From: George Cressall <[REDACTED]>
Sent: 24 June 2022 17:37
To: Eve Ramsden <[REDACTED]>
Subject: Re: 22/00988/FULHH 6 Lodge Road

1 – The description states "Proposed single storey side extension, including demolition and replacement of existing outbuilding." However I do not have plans for a new outbuilding ? are you referring to the existing extension as the outbuilding ? I believe it maybe best to remove reference to the outbuilding as it may confuse readers into thinking the applicant is also applying for one. If there is an outbuilding proposed I will need plans to a scale of 1:100/ 1:50 showing the elevations and floor plans of this.

Drawing: PROPOSED PLANS & ELEVATIONS		Address: 6 LODGE ROAD LITTLE OAKLEY CO12 5ED	
Project: PROPOSED REAR/SIDE EXTENSION		drawing number: LR.22.02	
scale: 1:100@A2	date: June 2022	drawn:

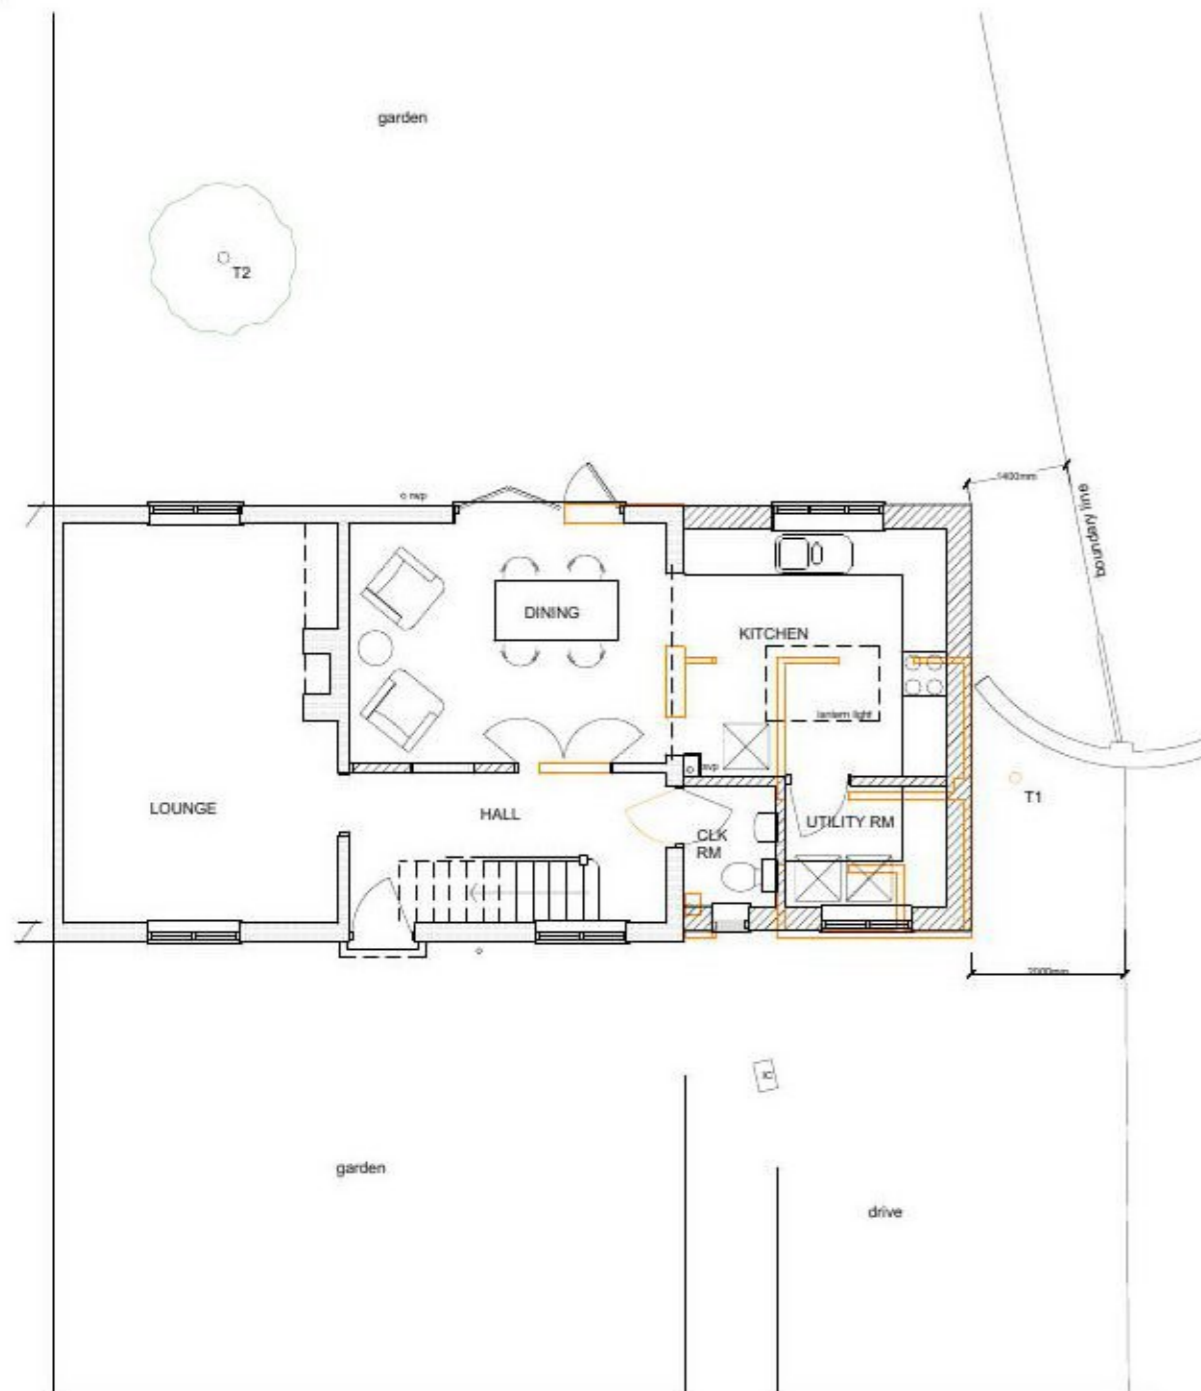
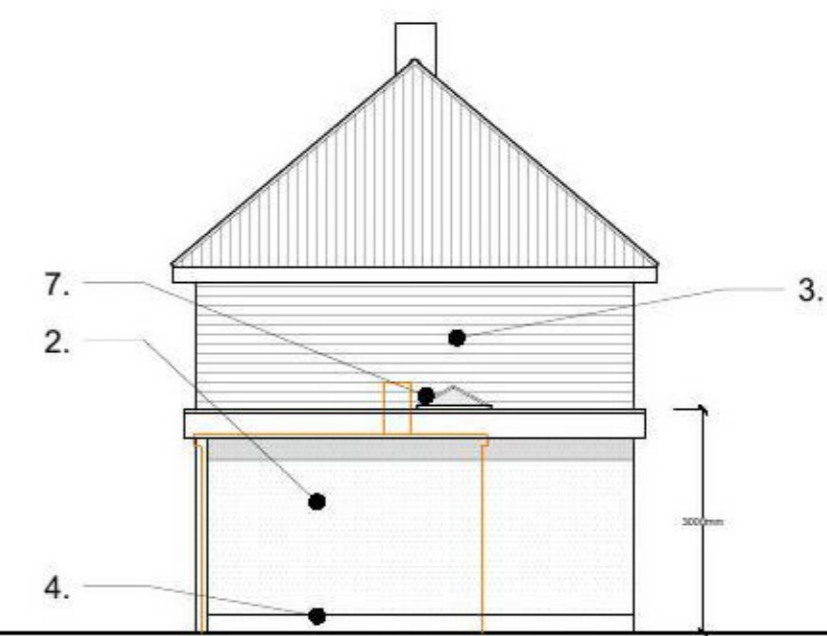
2 – The plans also show that the house will be rendered and clad as part of the development. Please confirm your agreement for this to be added to the description.

3 – Please provide the colour of the render and cladding to be used.

You are correct: it's just an extension-no outbuilding, so happy to change the description. Render colour has yet to be selected, but it'll either be a generic 'cream' or 'gray'.
